CITY OF ALBUQUERQUE

**RE: Guardian Storage- Juan Tabo
4909 Juan Tabo NE
Conceptual Grading and Drainage Plan Stamp Date: none
Hydrology File: F21D081**

Based on the submittal received on 11/12/19, the Conceptual Grading and Drainage Plan cannot be approved until the following are corrected:

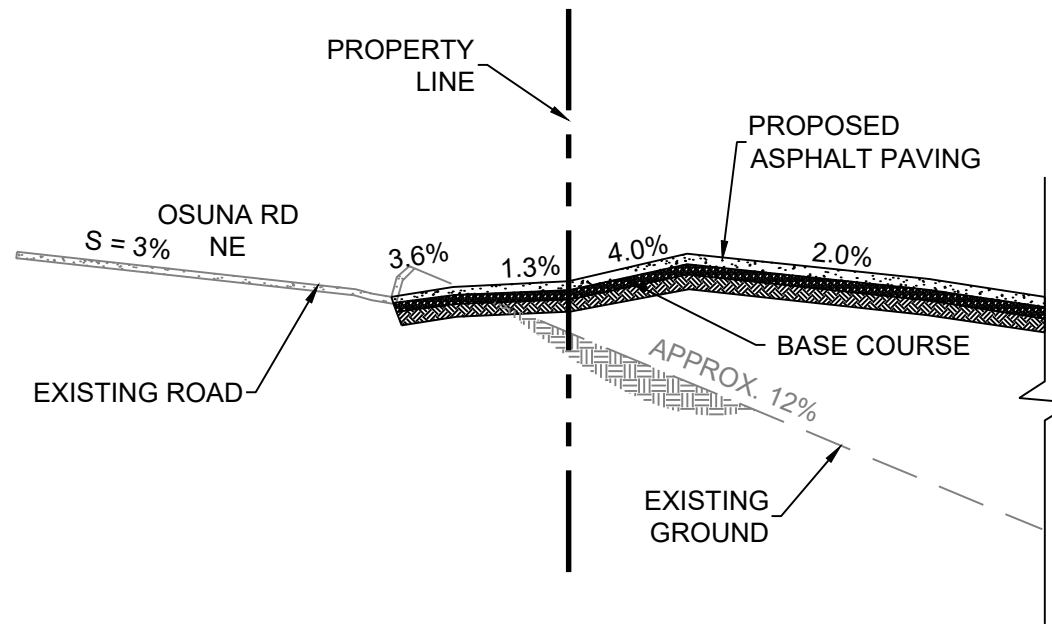
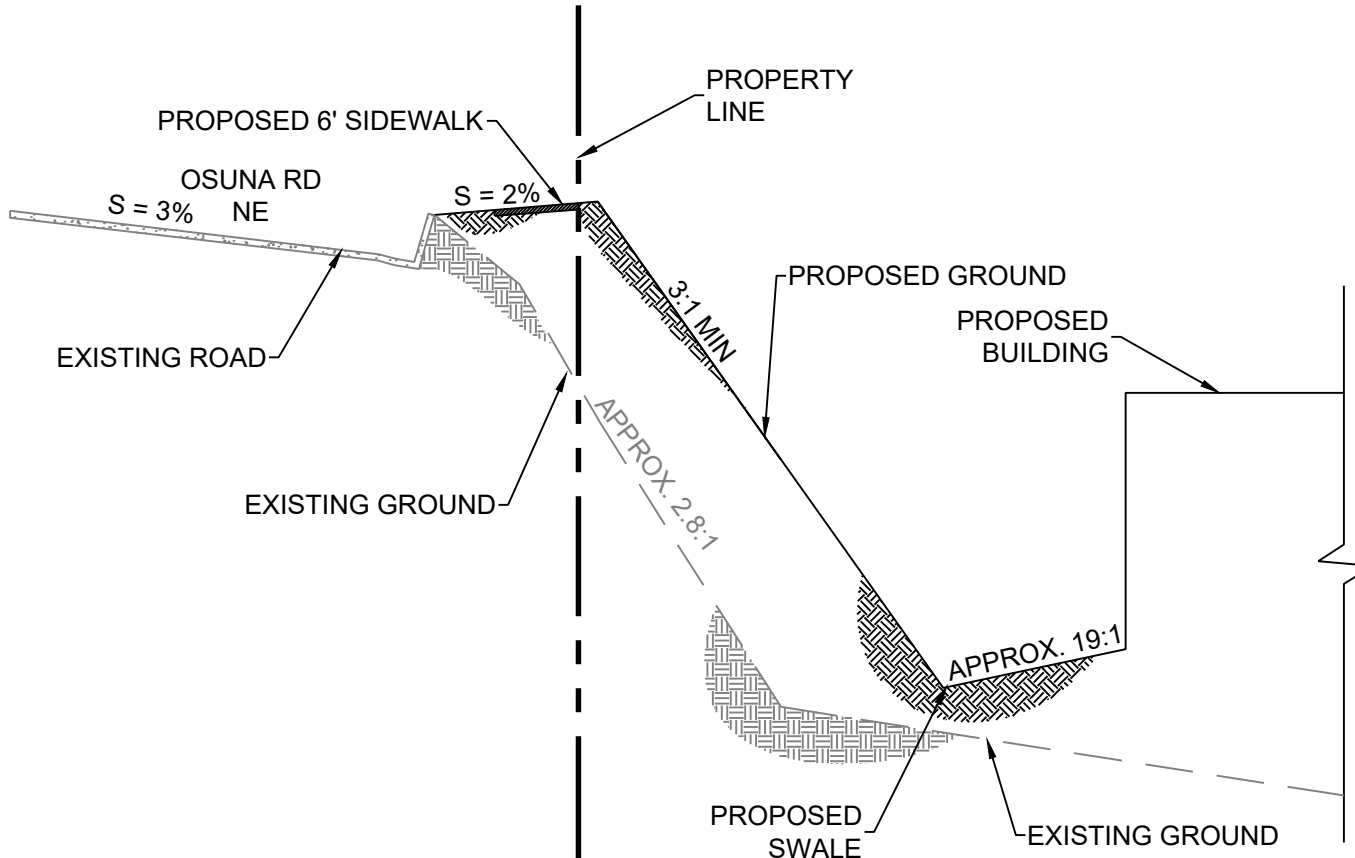
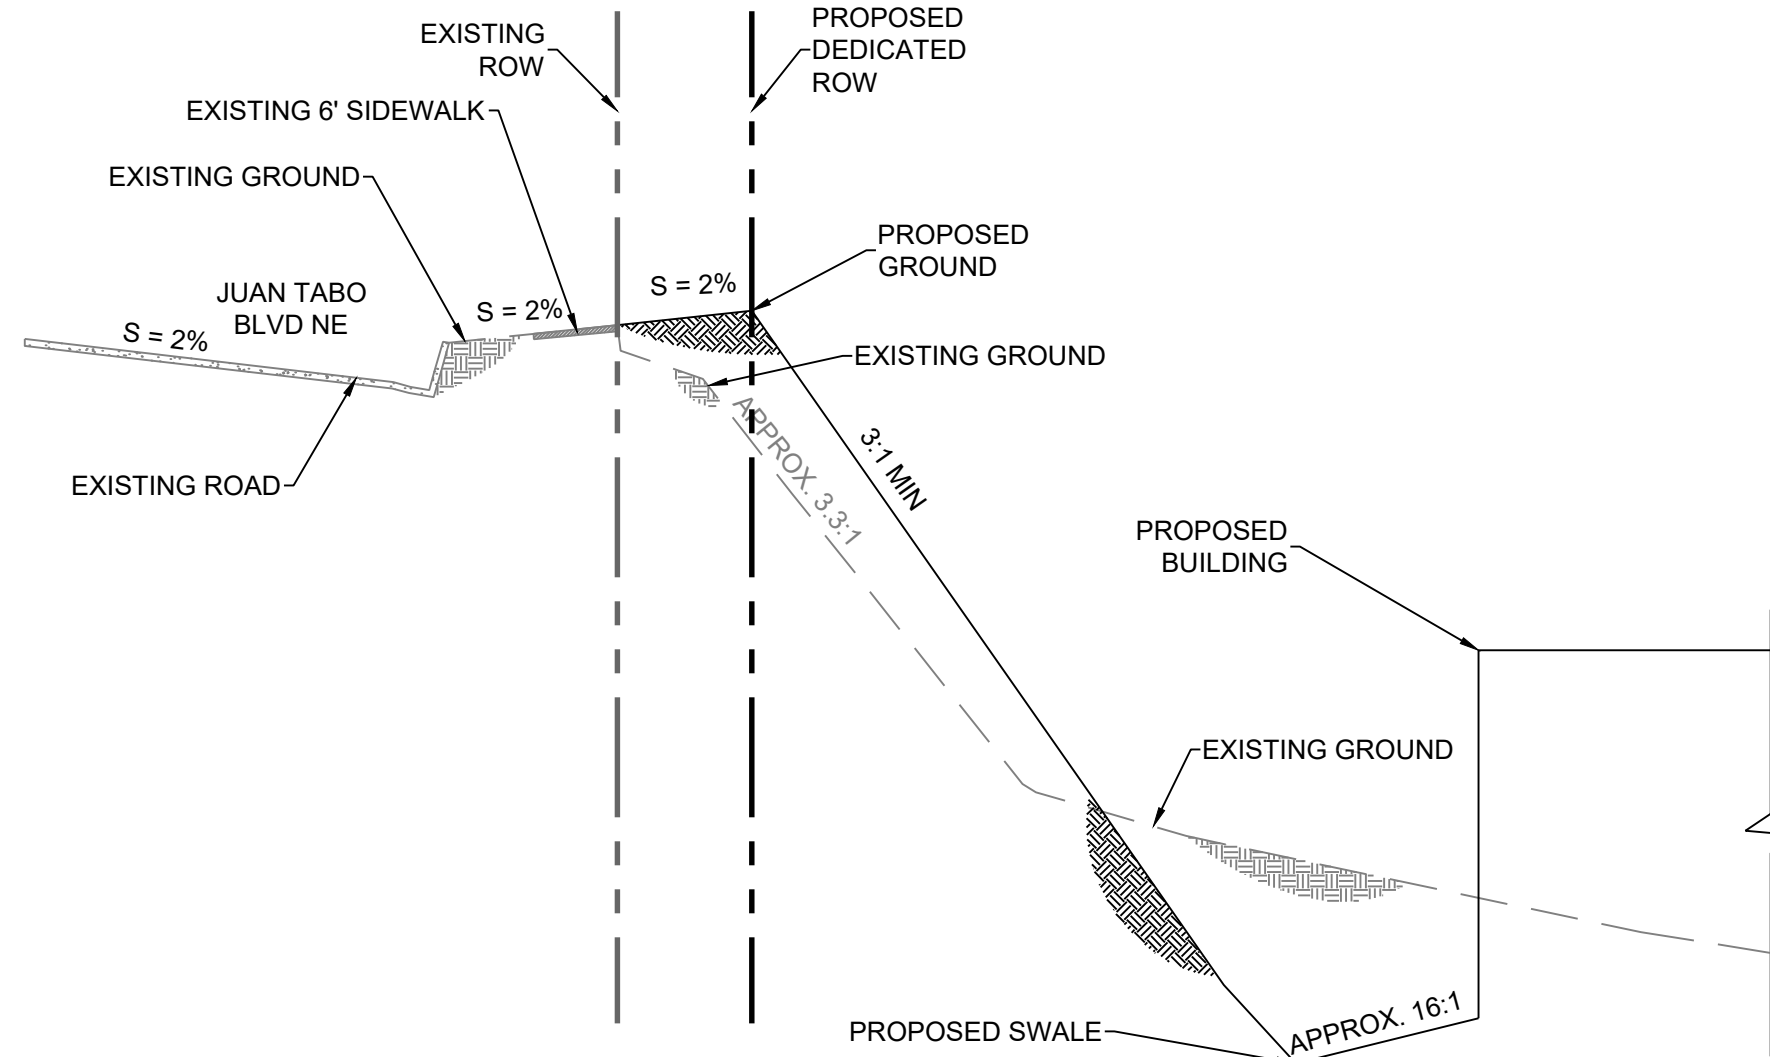
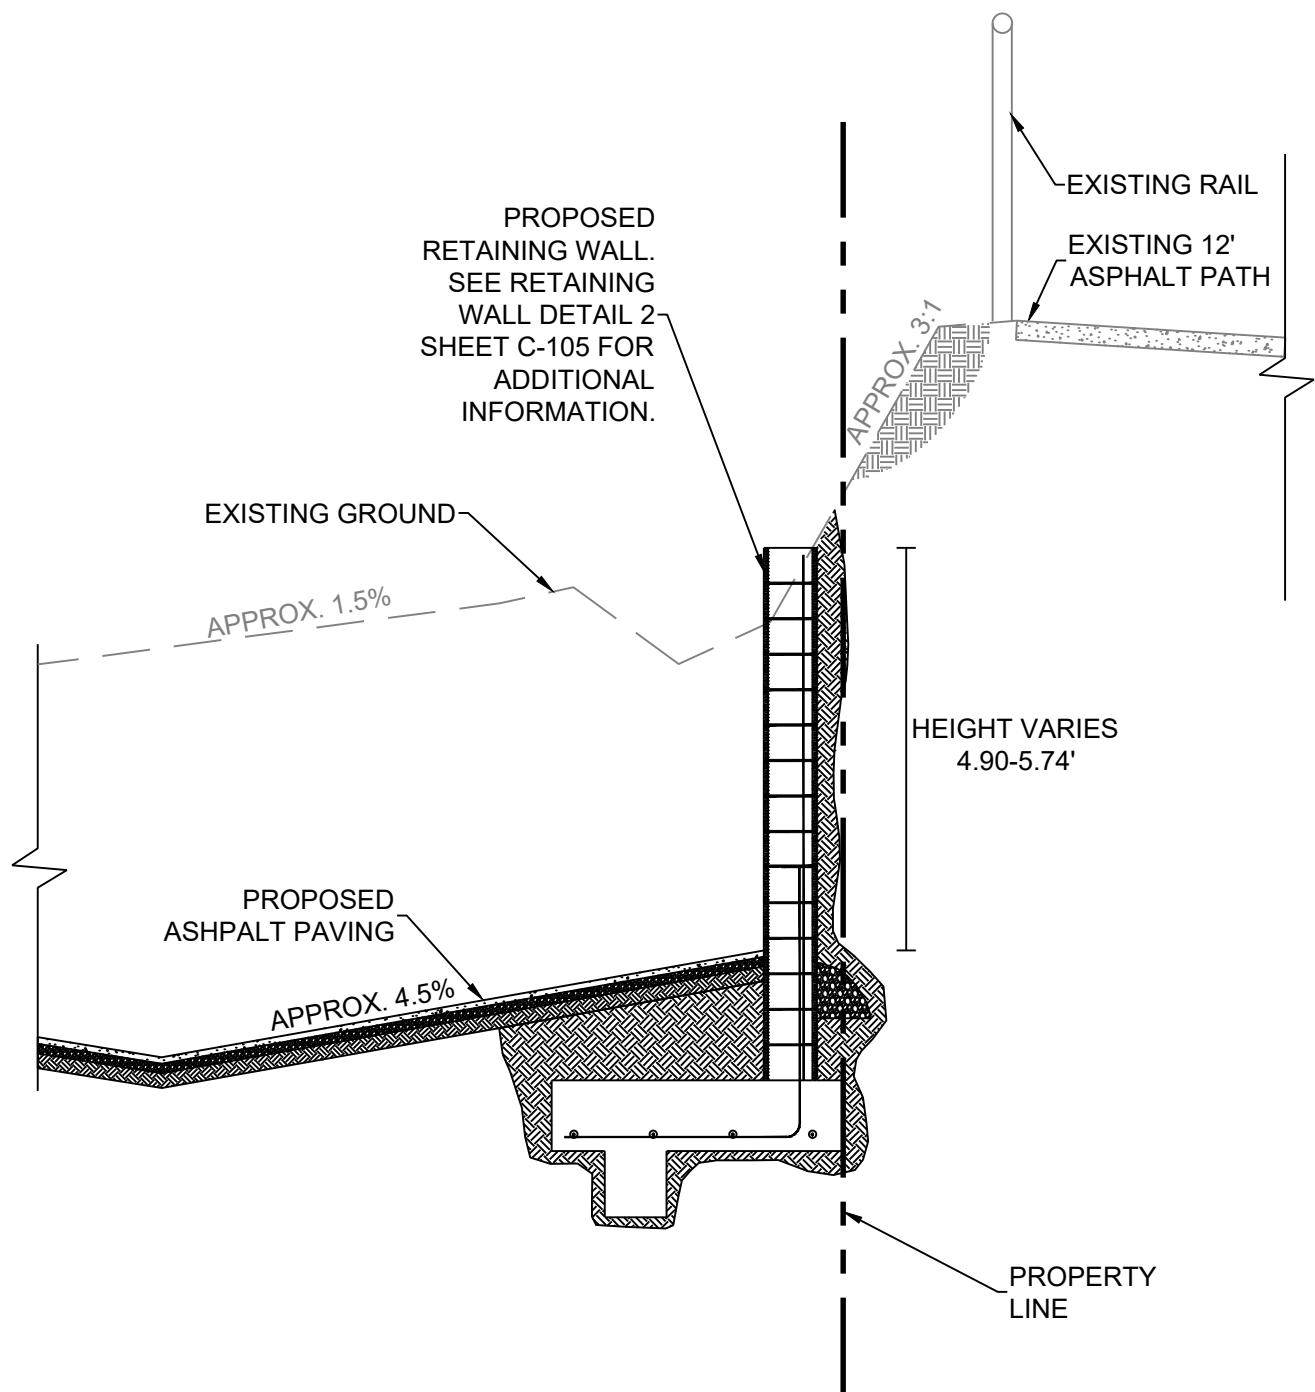
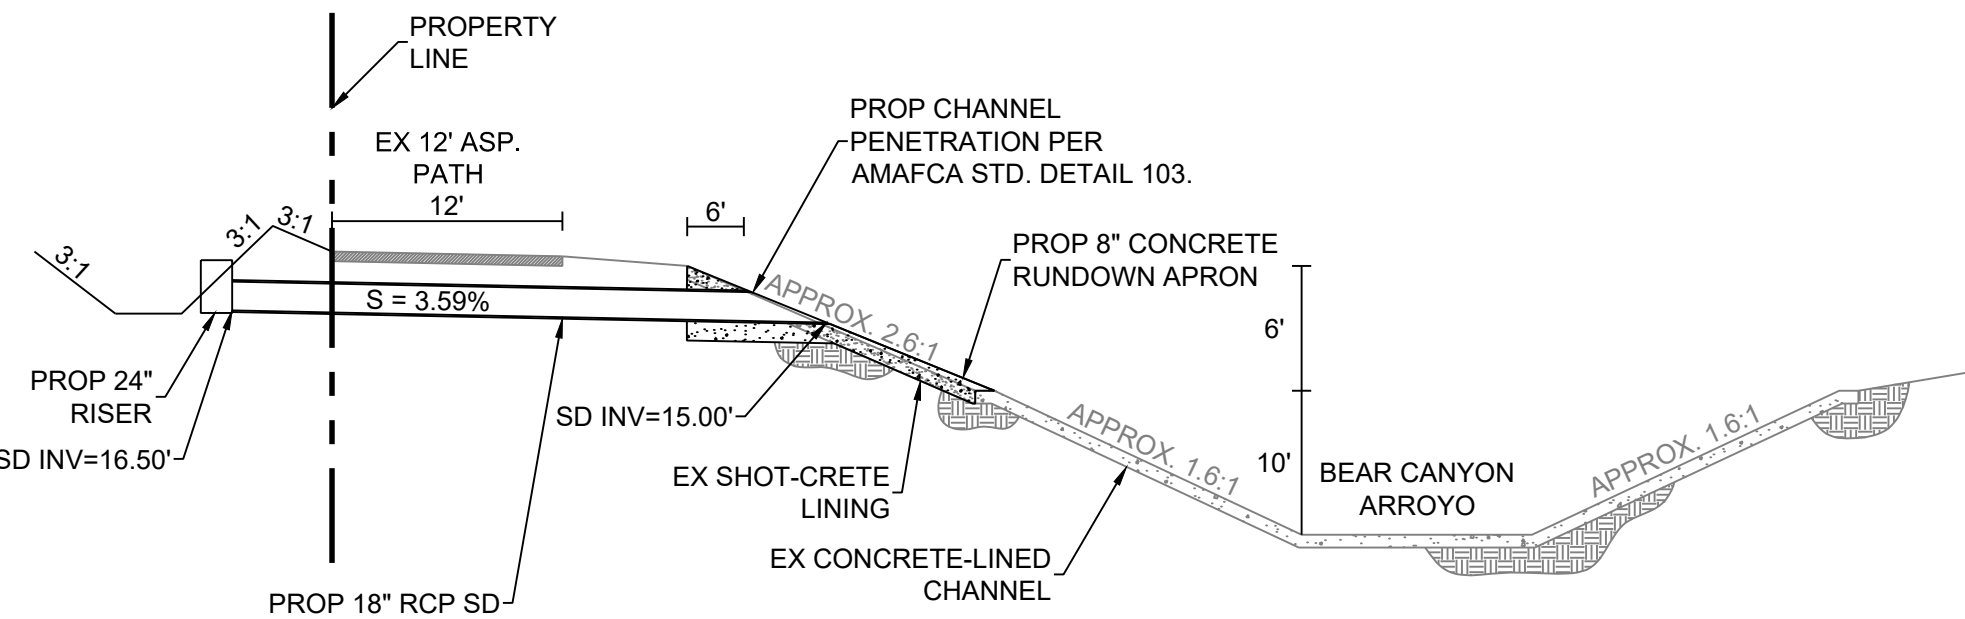
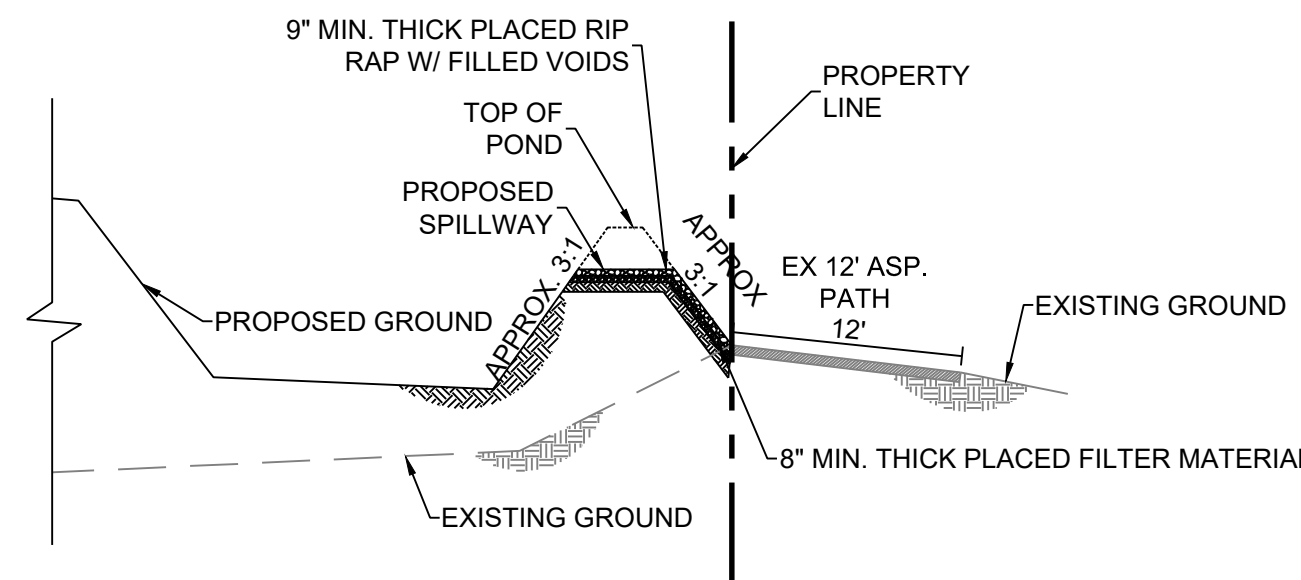
8. Provide sections through all external boundaries, especially the retaining wall adjacent to the arroyo, showing proposed retaining walls, garden walls, property/ROW lines, existing and proposed grades. In accordance with DPM Ch.22, section 5 part B, grading and wall construction near the property line may not endanger adjacent property or constrain its use.
9. Only one paper copy (plus the pdf) is required for Hydrology submittals.
